**RE: Winrock Road B Extension
2100 Louisiana Blvd NE
Grading and Drainage Plan
Engineer's Stamp Date: 11/9/18
Hydrology File: J19D058G**

Based on submittal received on 11/9/18, the Grading Plan cannot be approved for Site Plan for Building Permit until the following are corrected:

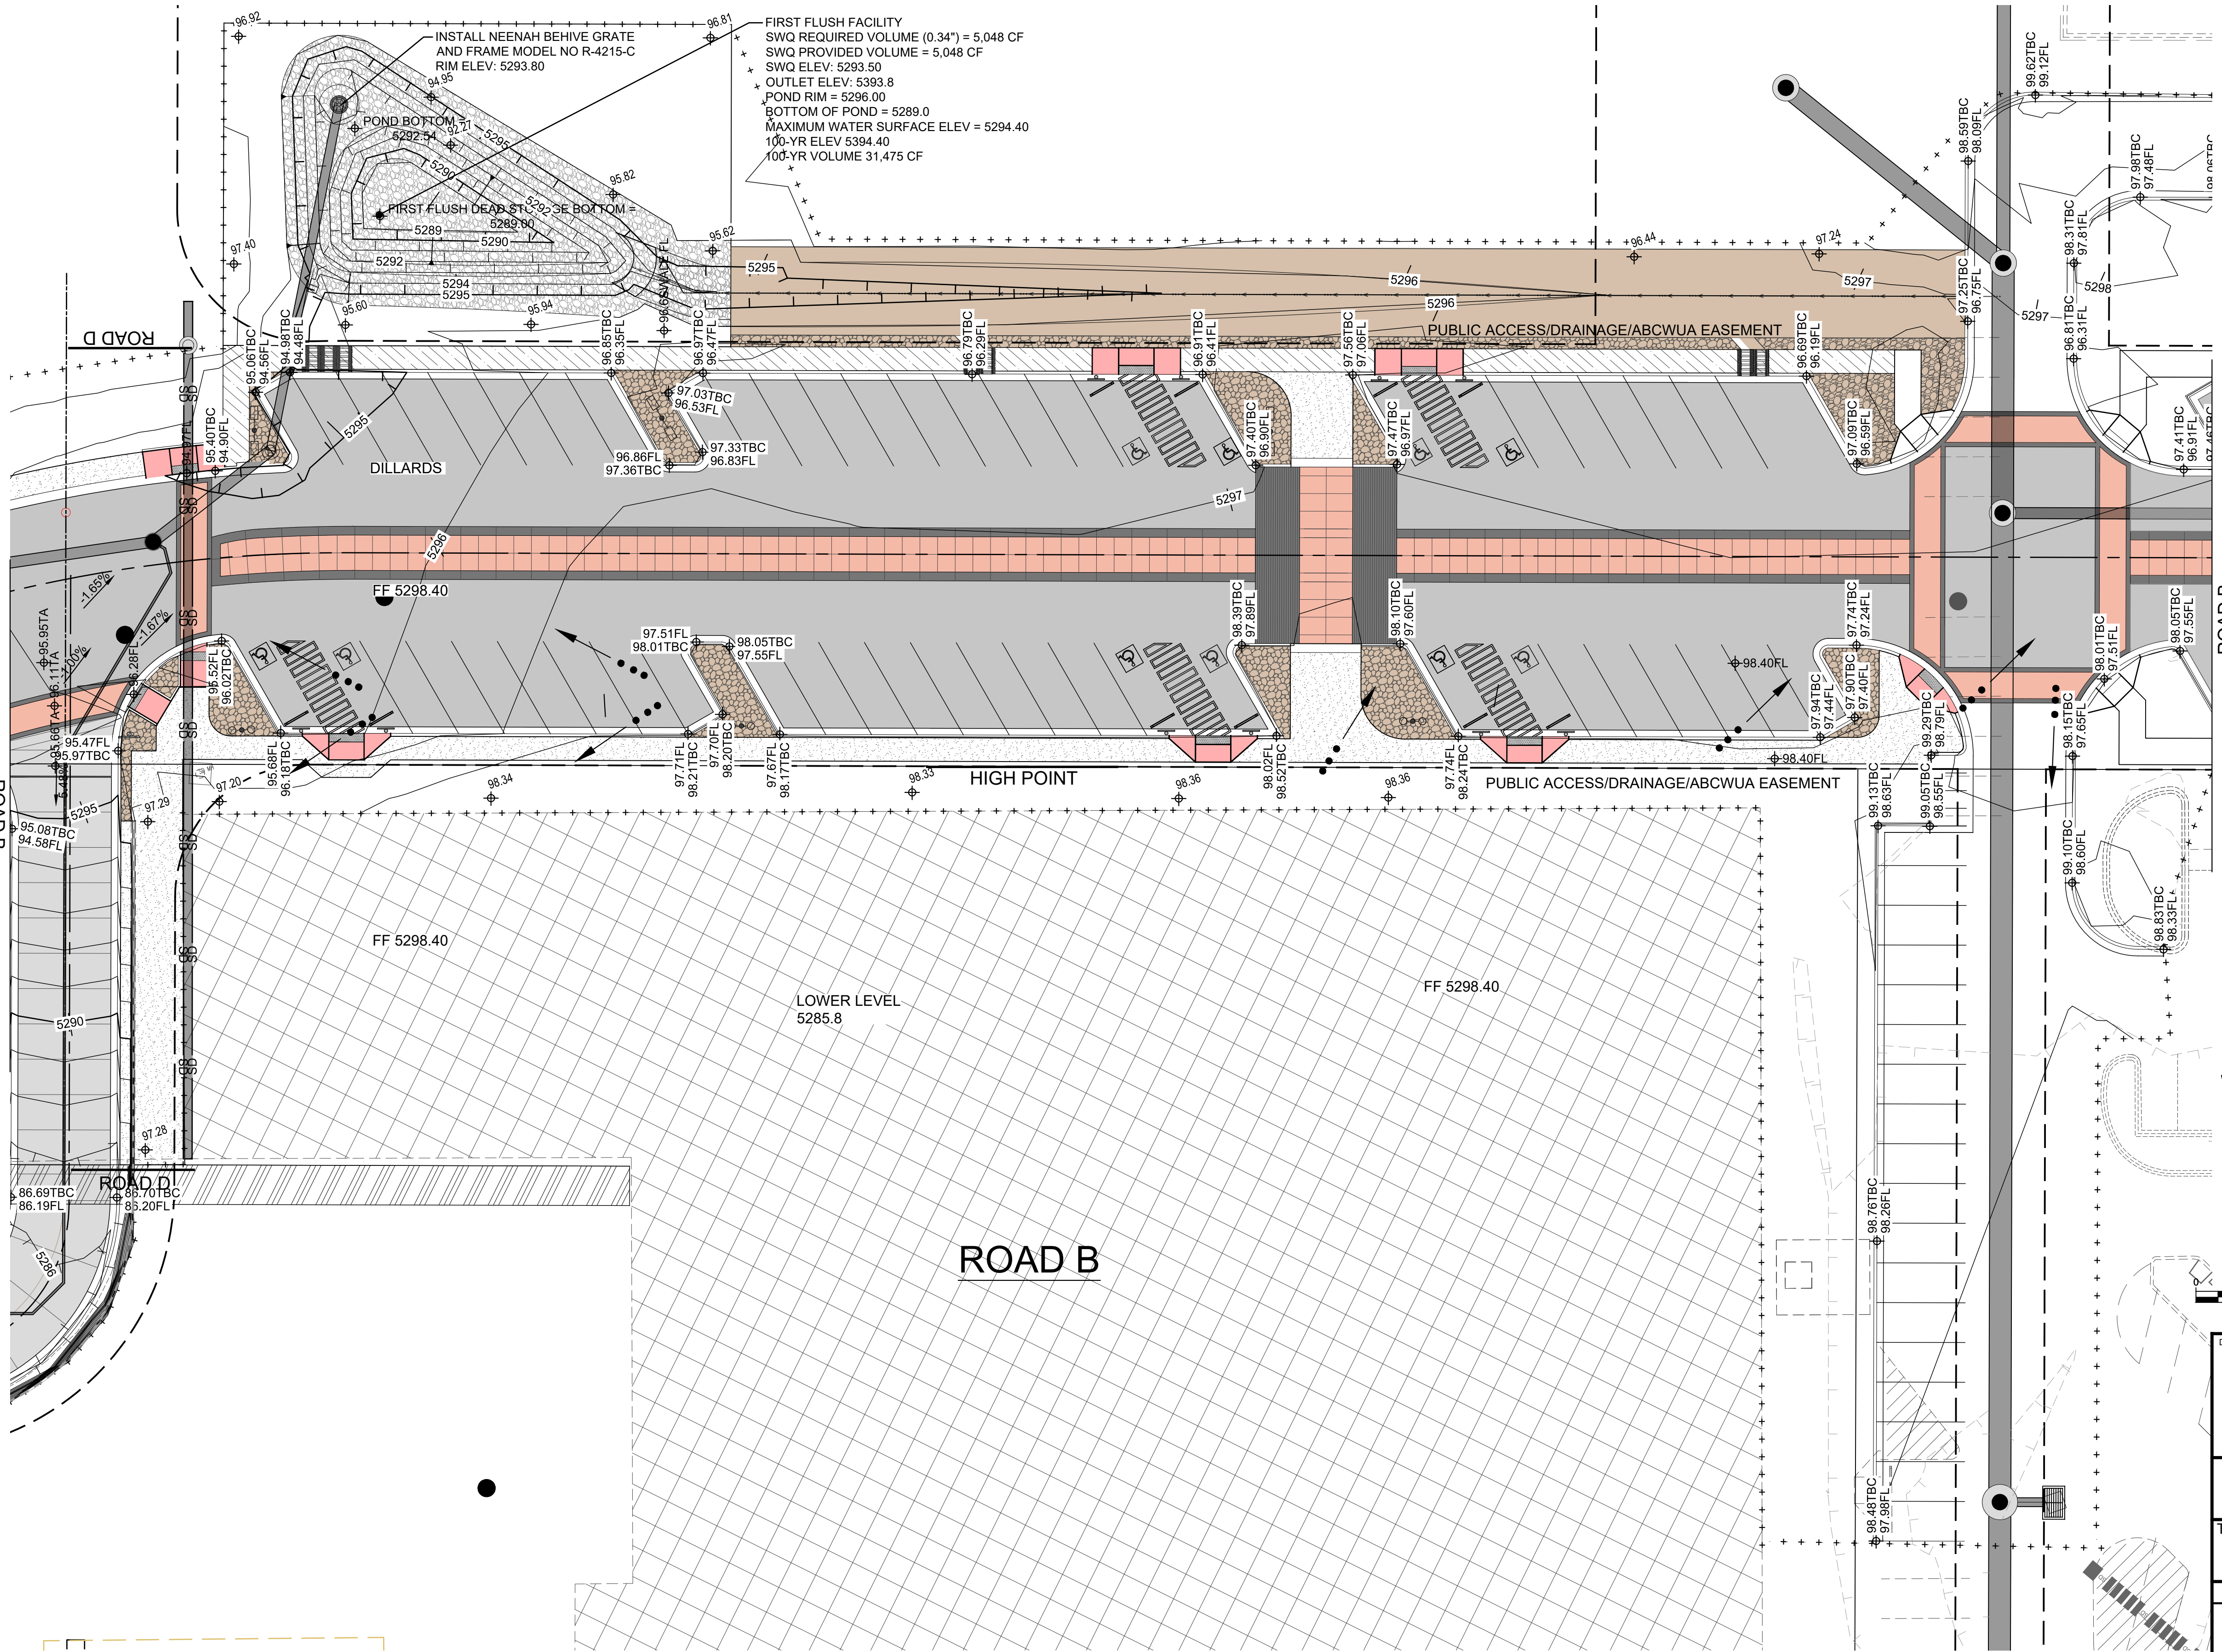
1. A digital (.pdf) submittal, emailed to PLNDRS@cabq.gov is required.
2. Label existing contours, show and label all proposed contours. Provide existing and proposed spot elevations.

6. How will stormwater be prevented from entering the parking garage? The High Point needs to be supported with elevations and depth of flow calculated at the top of the ramp along Road B. A drain will be needed at the base of the ramp and will need to be able to discharge downstream, either by sump pump or gravity.

TITLE: SWQ POND SECTION

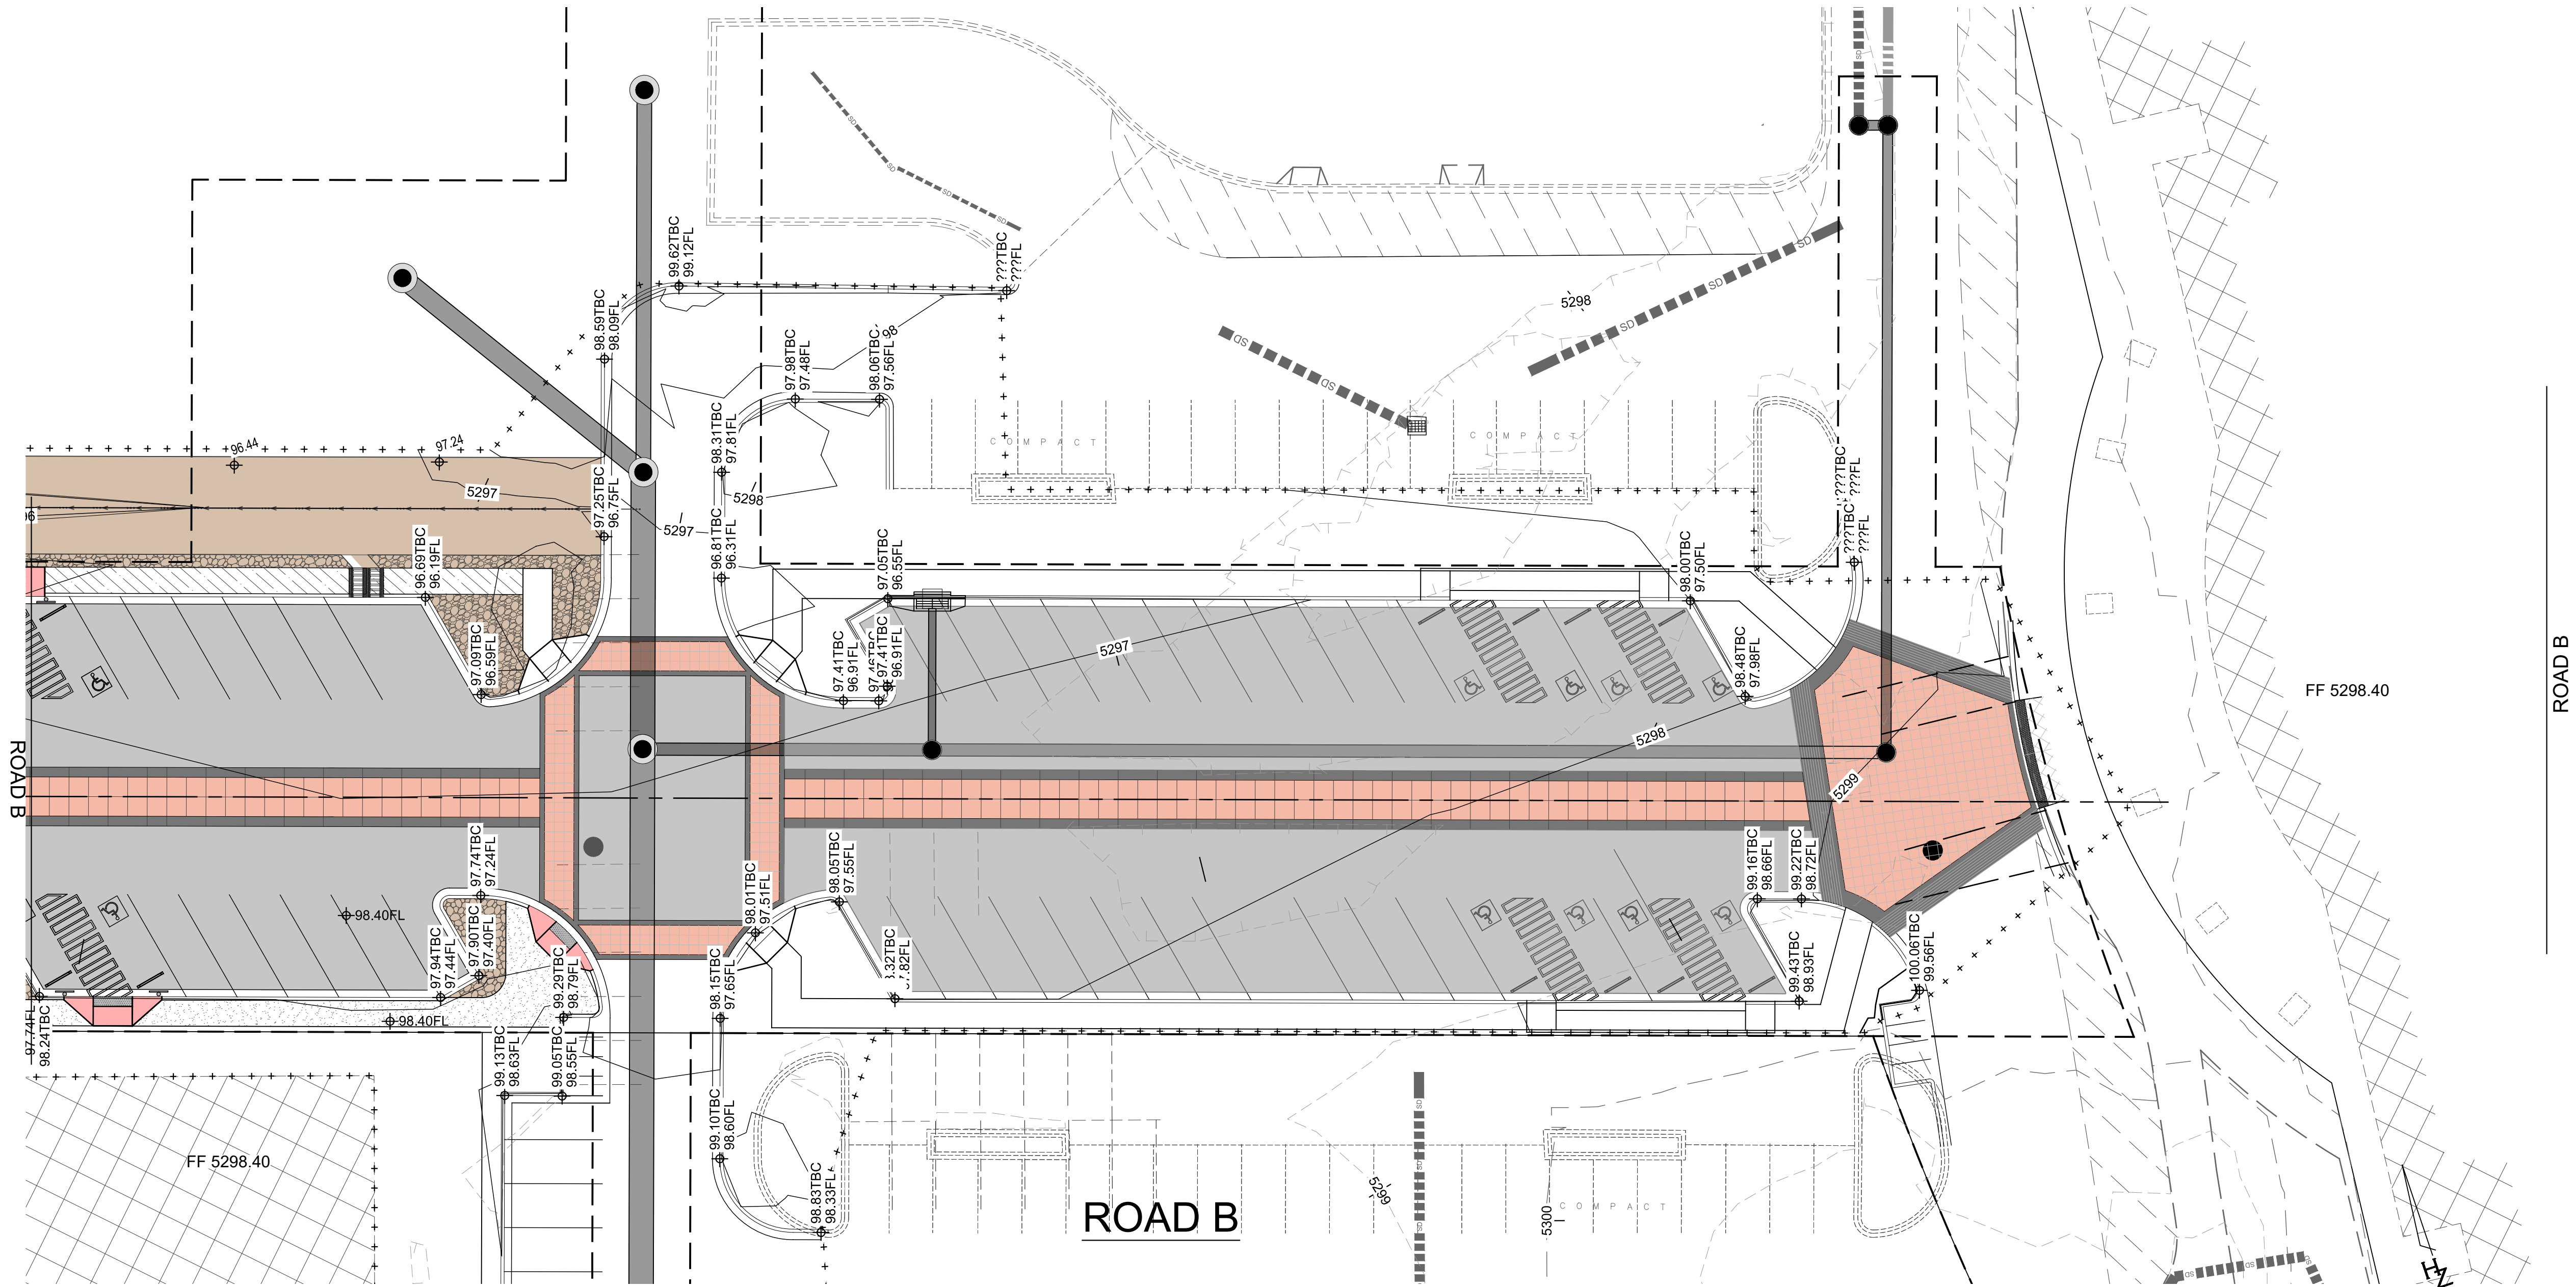
5. Additional information is needed for the First Flush Facility. Is it underground storage or surface ponding? Is it public or private? Provide pond details such as stormwater quality water surface elevation, 100-yr WSE, top of pond bottom of pond, include sections.
